Please ask for: Ms Iqraa Malik
Email: iqraa.malik@terraquest.co.uk
Telephone: 0121 234 1390
Our Ref: AL/20/25/A
Your Ref:
Date: 5th March 2025

Application for Consent to Display an Advertisement(s)

Development: Installation of various signage.
Location: Shop Around The Clock And Aldingbourne Post Office Westergate Street
Westergate PO20 3QL

Item 3  
Two Digitally printed vinyl graphics  
applied to glazing.  
Size: As shown  
Scale: 1:10

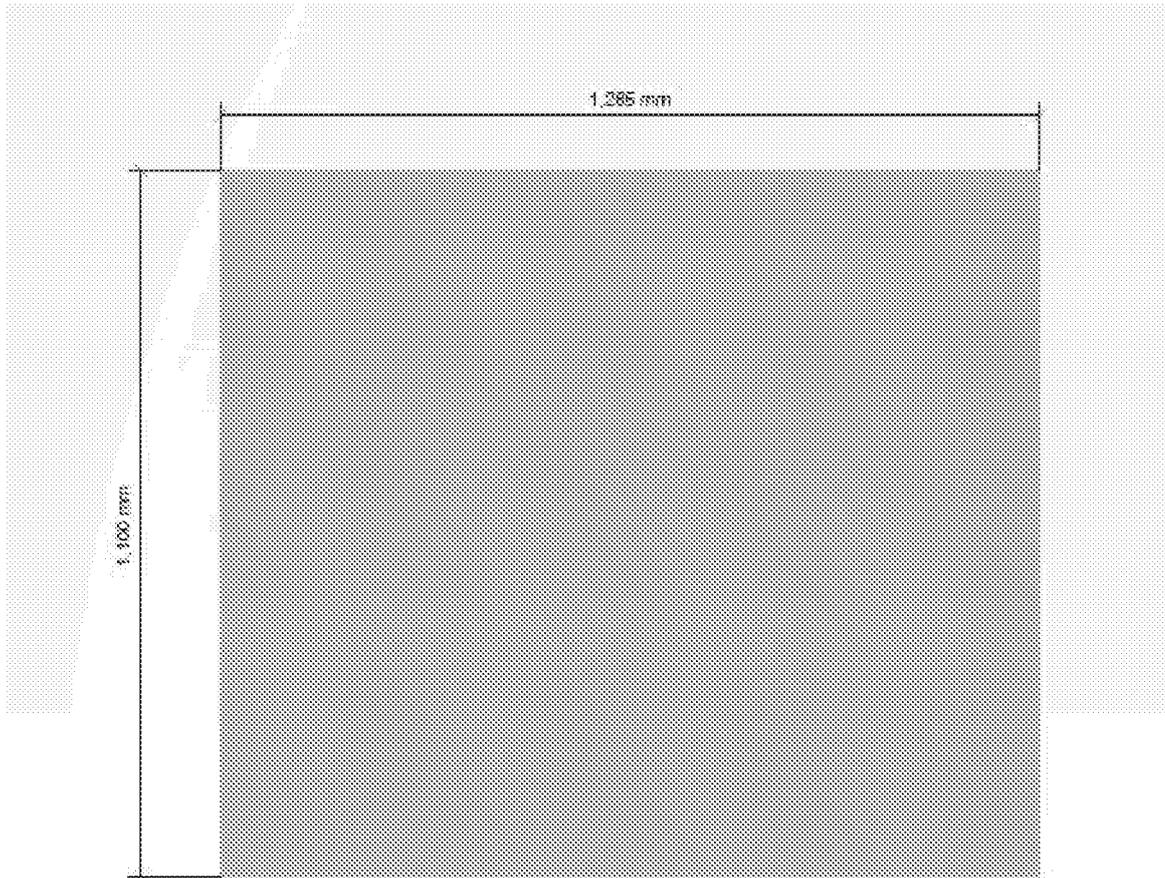
Item 3

The scale listed for item 3 is 1:50, however it appears to measure to a scale of 1:10, please review and amend. In addition to this, the height and width for this sign have been mixed up on the application form, please amend.
